Application for Planning Permission for Works or Extension to a Dwelling

Development: Proposed oak framed carport to northern end of existing dwelling.
Location: Longacre Maypole Lane Yapton BN18 0DR

I regret that I am unable to accept your documents as a valid application until the following item(s) have been received or resolved :-

EXISTING PLAN AND ELEVATIONS

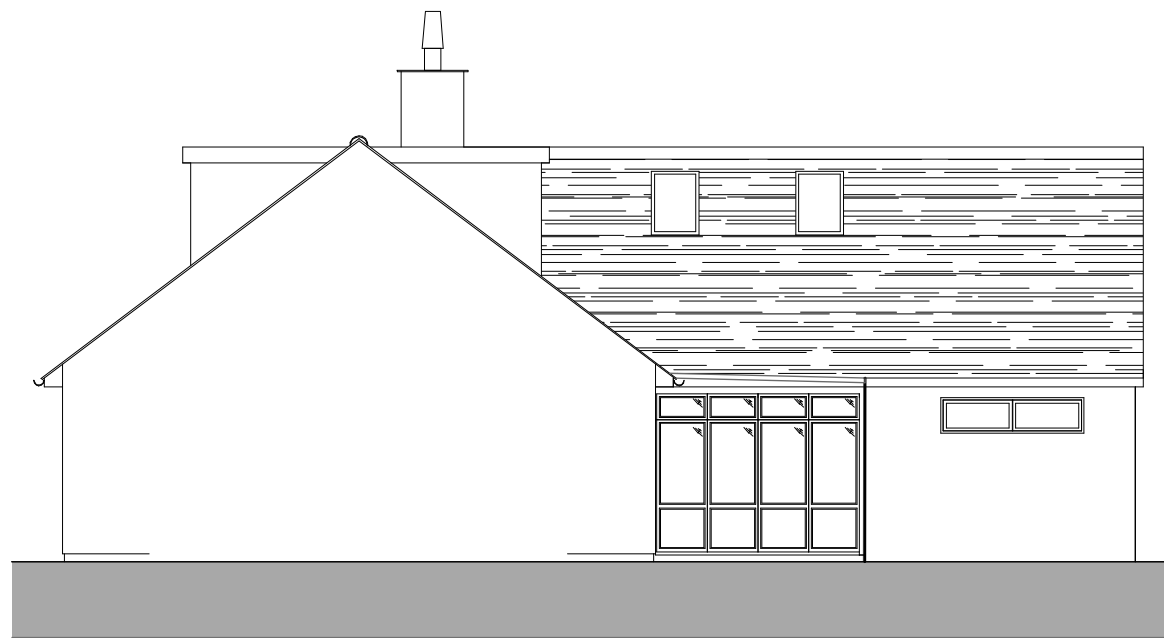
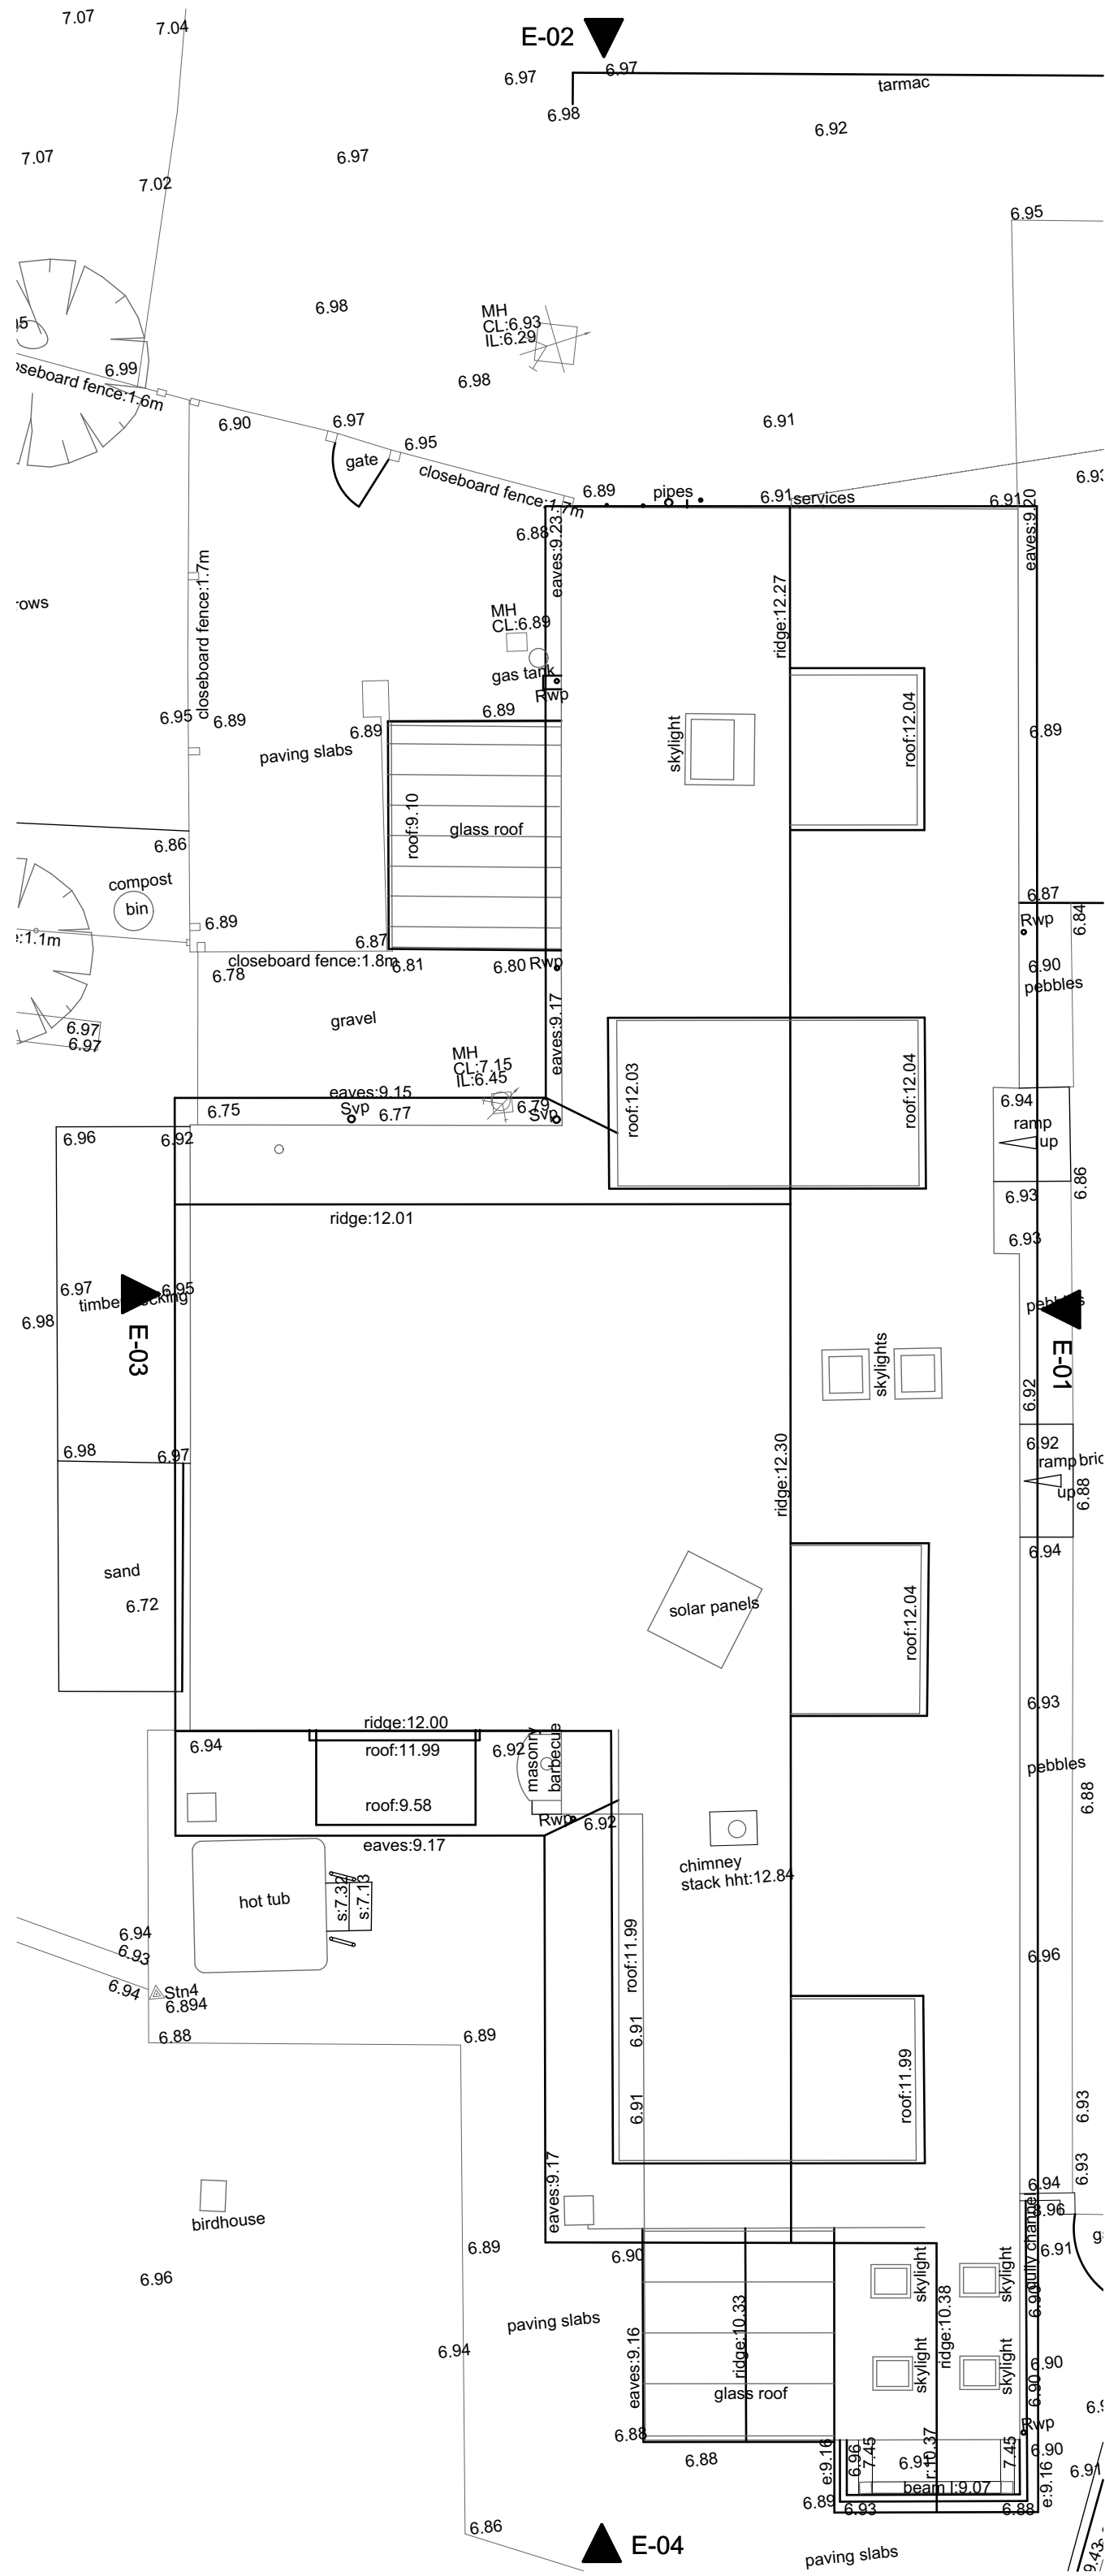
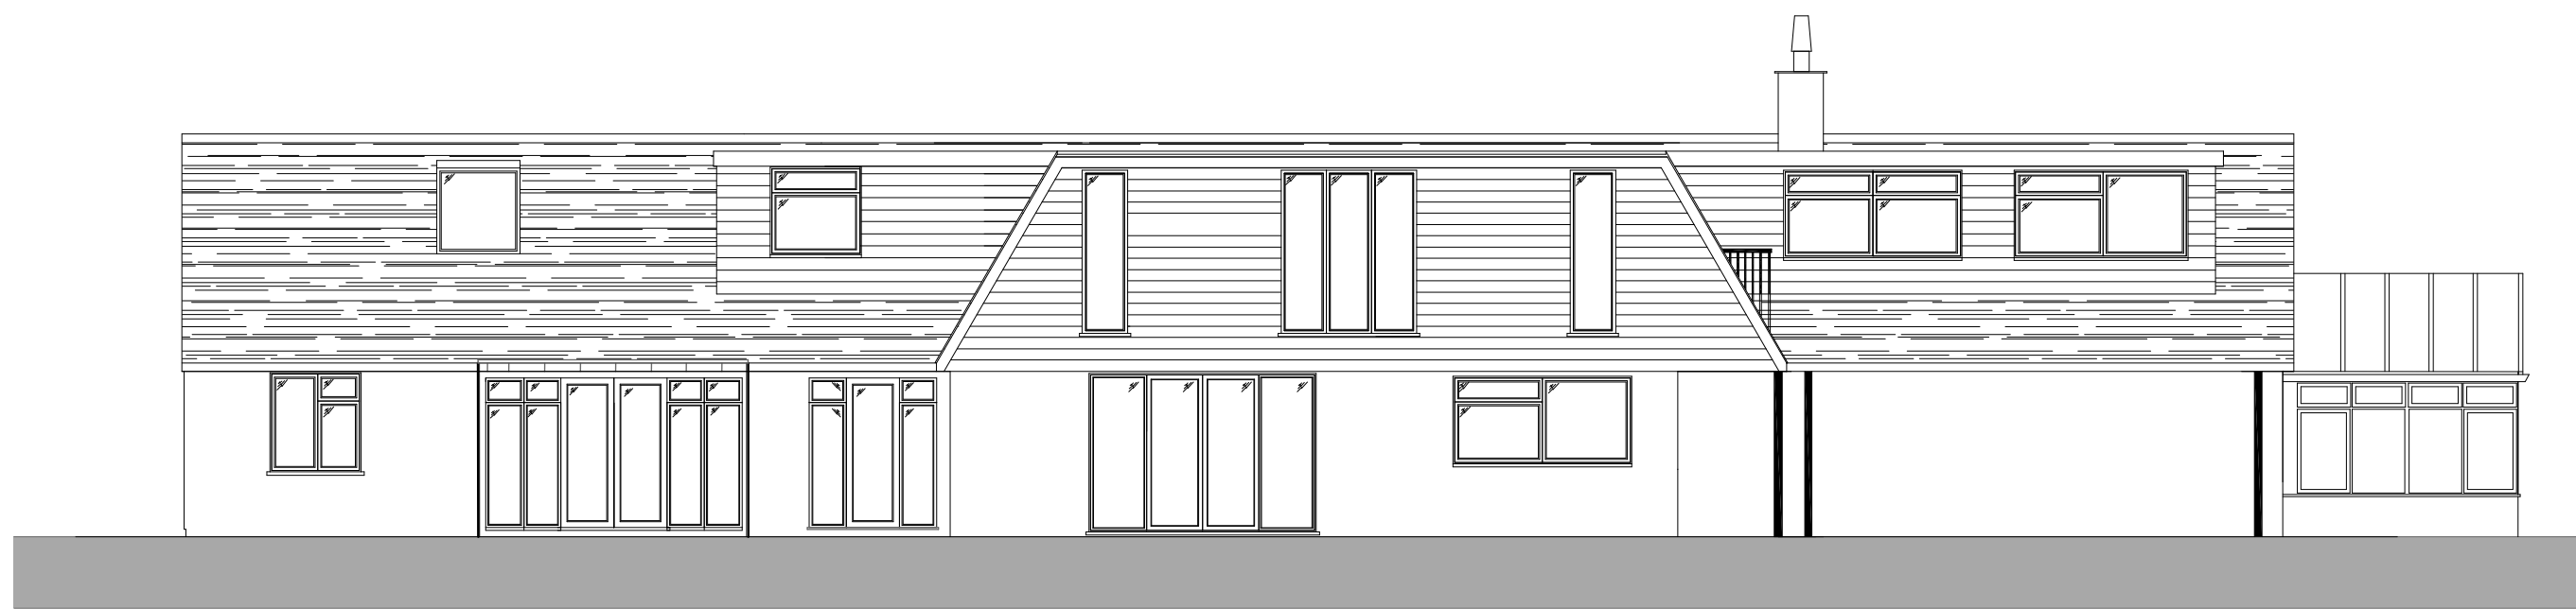
Existing Elevations

The existing elevations have not been submitted correctly, the drawings are partly missing, please review and resubmit.
